SEA LINK – DEVELOPMENT CONSENT ORDER - PINS REFERENCE
EN020026

Interested Party submission by N Bridges RIBA
June 2025

- 1.1. National Grid Electricity Transmission – Sea Link Application
PINS ref. EN 020026

- B3: Yox Valley
- B4: Fromus Valley
- B5: Alde Valley
- D3: Minsmere and Sizewell Coast
- D4: Thorpeness to Aldeburgh
- J4: Alde Estuary
- K3: Aldringham and Freston Sandlands
- K4: Rendlesham and Tunstall Sandlands
- L1: Heveningham and Knodishall Estate Claylands
- O1: Benhall Estate Sandlands

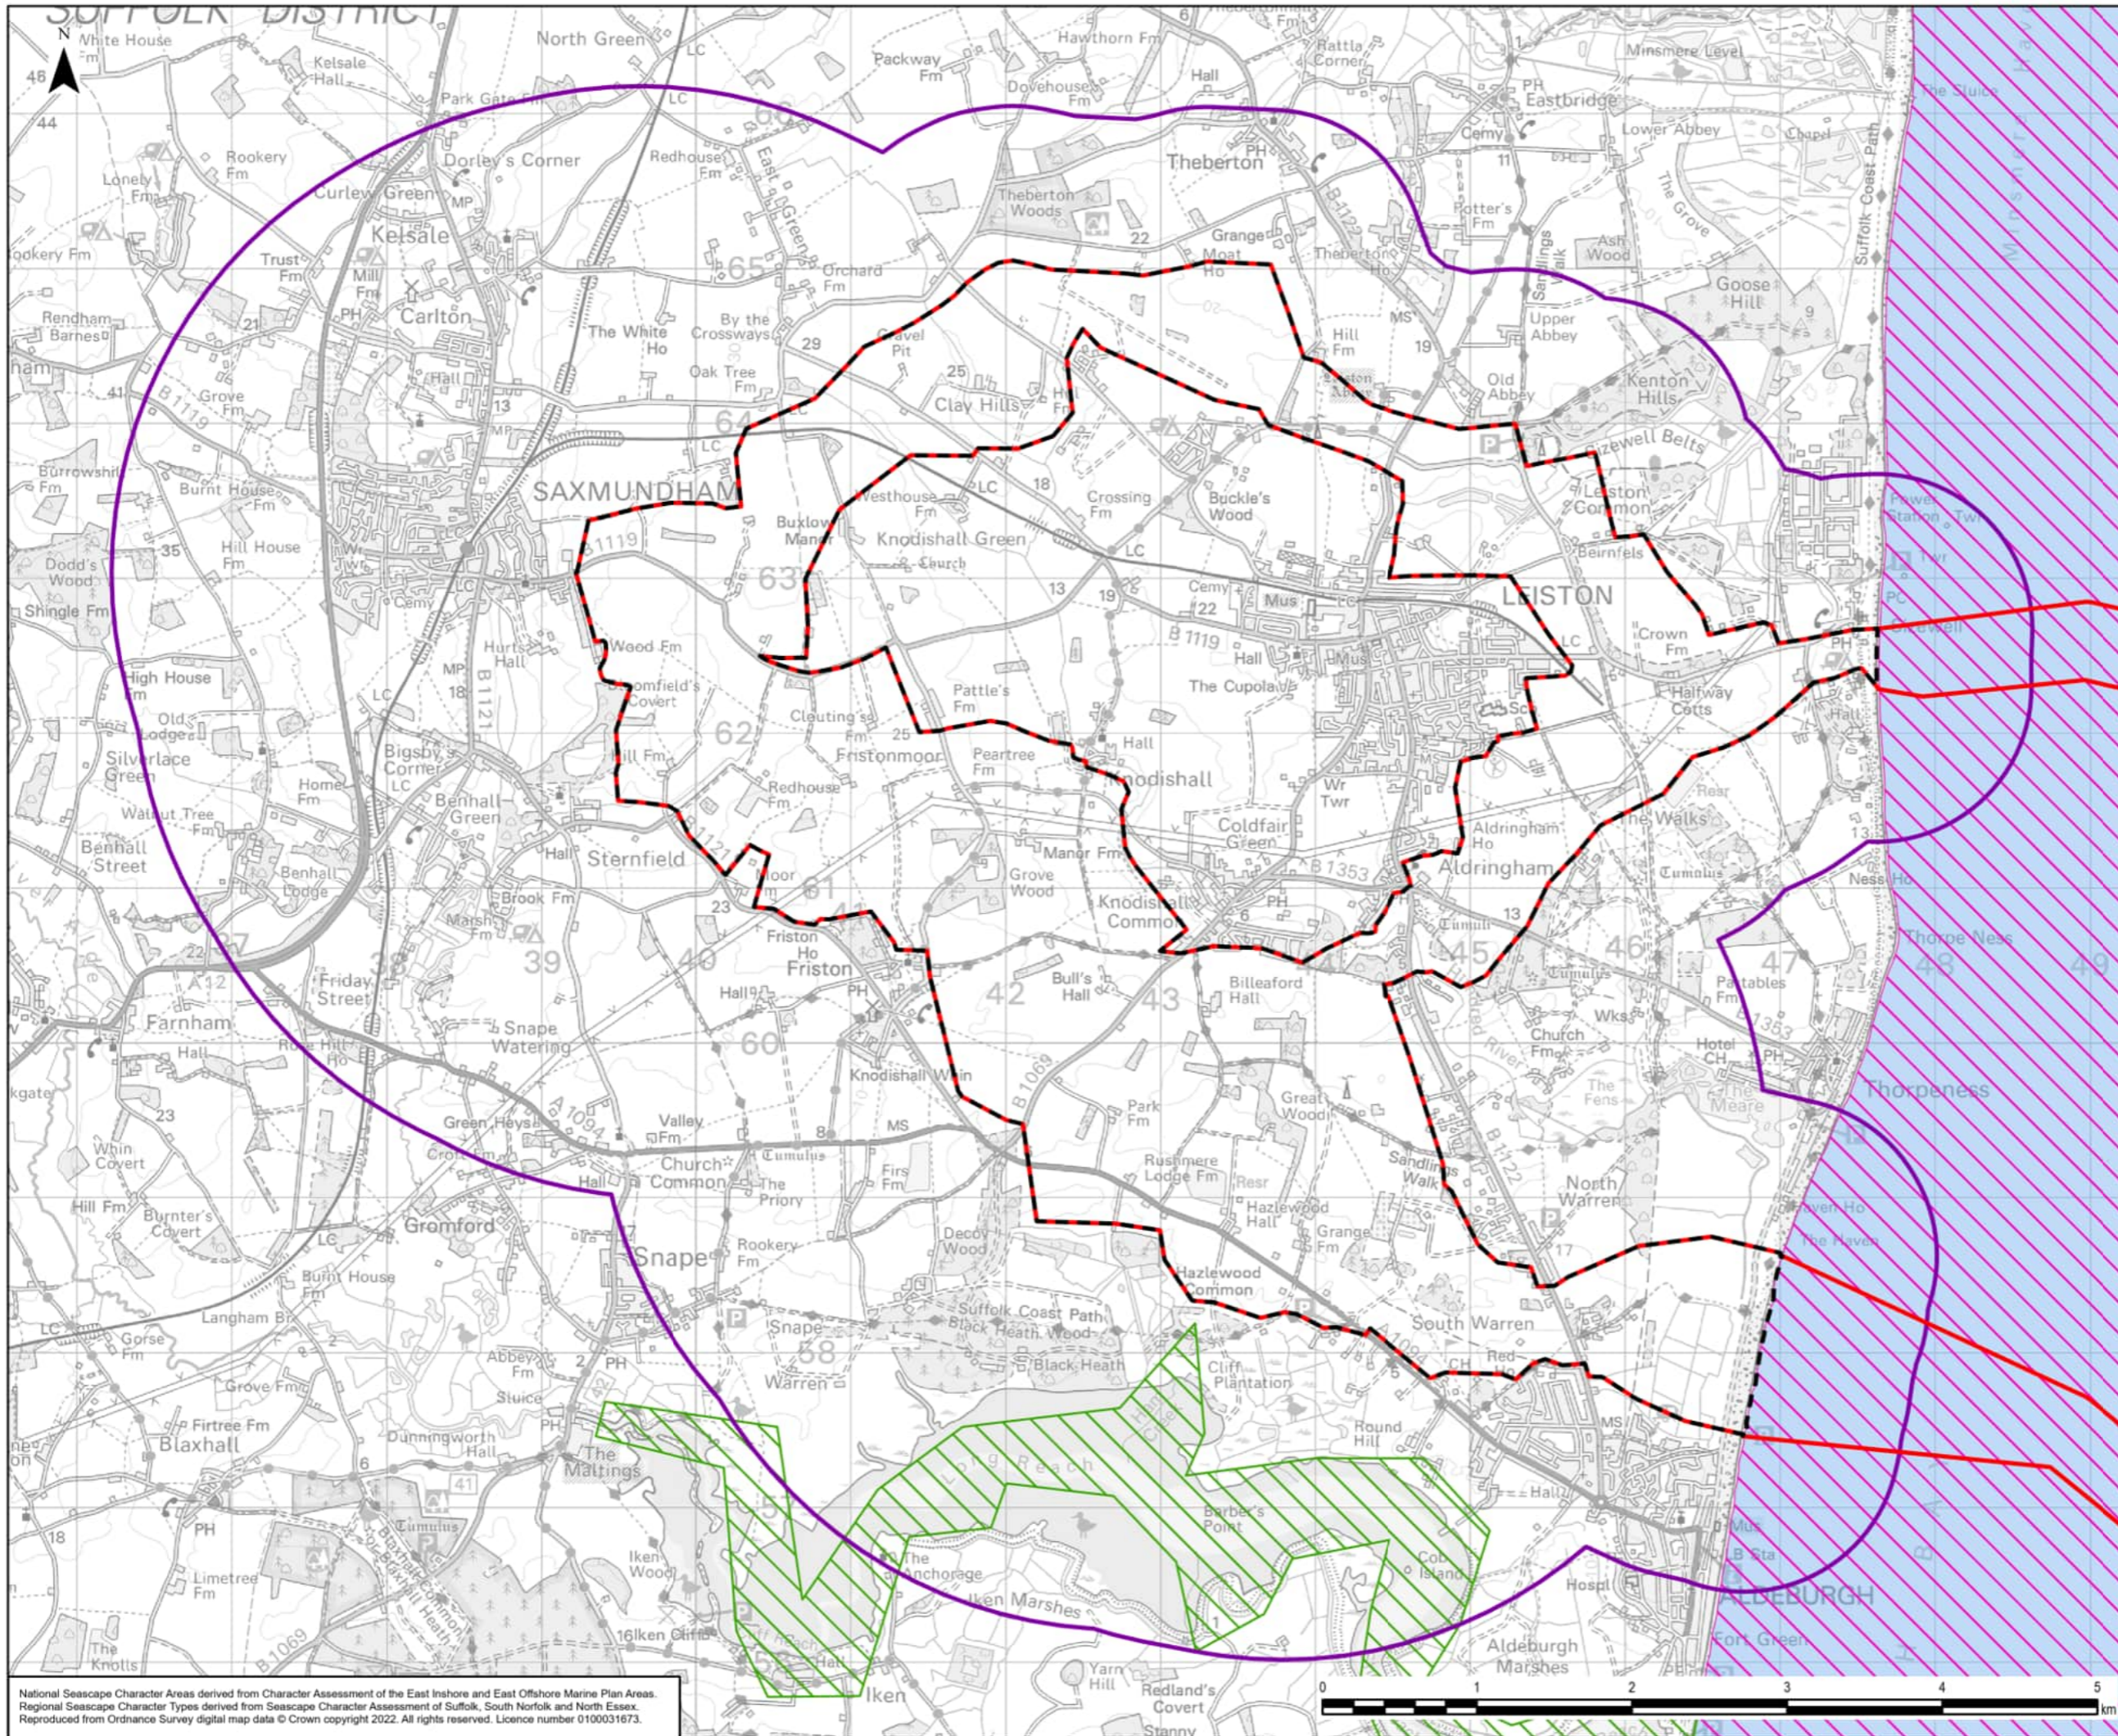
3.16. Note that the Area of Search excluded the Alde estuary as it did in the Landscape & Visual Figures (**Peir Vol. 3, Part 2, Chapter 2, Figures**). So, before the DCO Application, receptors were being excluded. The hatching of the AONB area was even excluded over the waters of the estuary, despite the AONB MP specifically stating that these were integral parts of the designated area.

- 3.26. The ExA is requested to ask NGET to include a proper assessment the Alde estuary in the Cultural Heritage and Landscape and Visual chapters of the ES. The model used to generate the ZTV plans should be run again further south to include the southern side of the Alde estuary, down to Tunstall Road on the ridge.
